Submission Form

Epping to Thornleigh Third Track Proposal. Application number SSI 5132.

Name(s): DR. STEVEN S. CLARE

Figure 5.6 Cross-section and elevation - New Cheltenham Station concourse building
Note: Indicatively added to future design

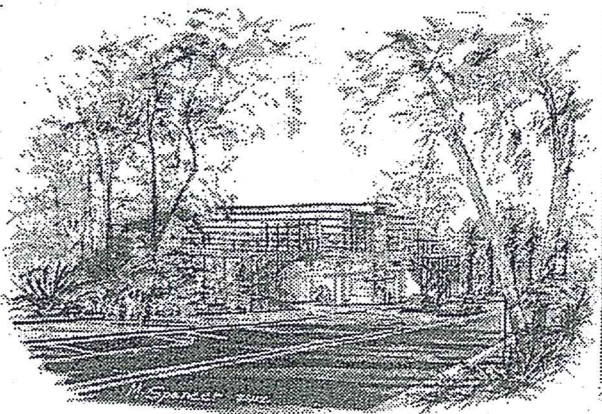
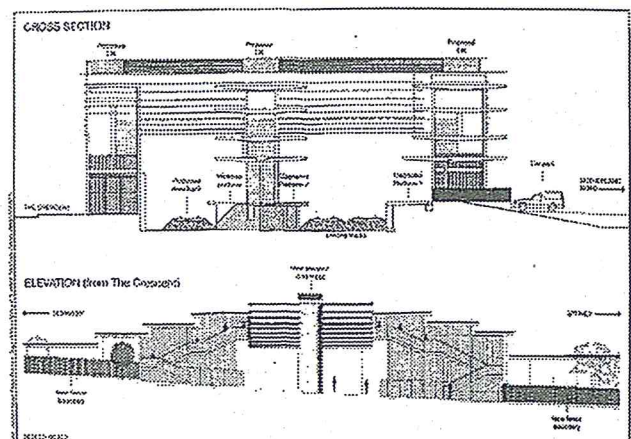
- The proposed redevelopment of Cheltenham Station shows no regard for the HCA. The visual impact of the proposed 13m high glass and steel concourse is totally unacceptable in this HCA.

Concept design drawing of proposed changes to Beecroft Station (Parsons Brinckerhoff 9/3/12). Former side platform shaded in pink.

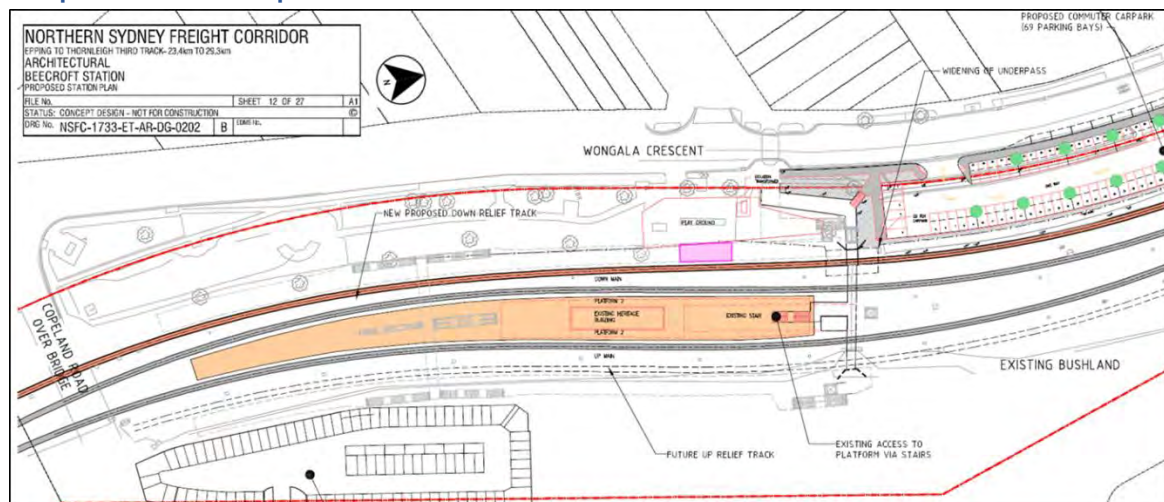
- There has been inadequate assessment of the project's impact on the fabric of the Beecroft Cheltenham Heritage Conservation Area (HCA).
- The plan given for Beecroft Railway station Precinct is vague. The relationship to the trees, playground and original 1895 platform located south of the present station is not shown. A fourth track is shown on the eastern side. The plan does not include urgently needed lifts to allow disabled access at Beecroft Station.

- Beecroft Station Gardens have a heritage listing with Hornsby Council but the impact on them has not been adequately addressed. No arborist's report is given for the trees which will be removed.
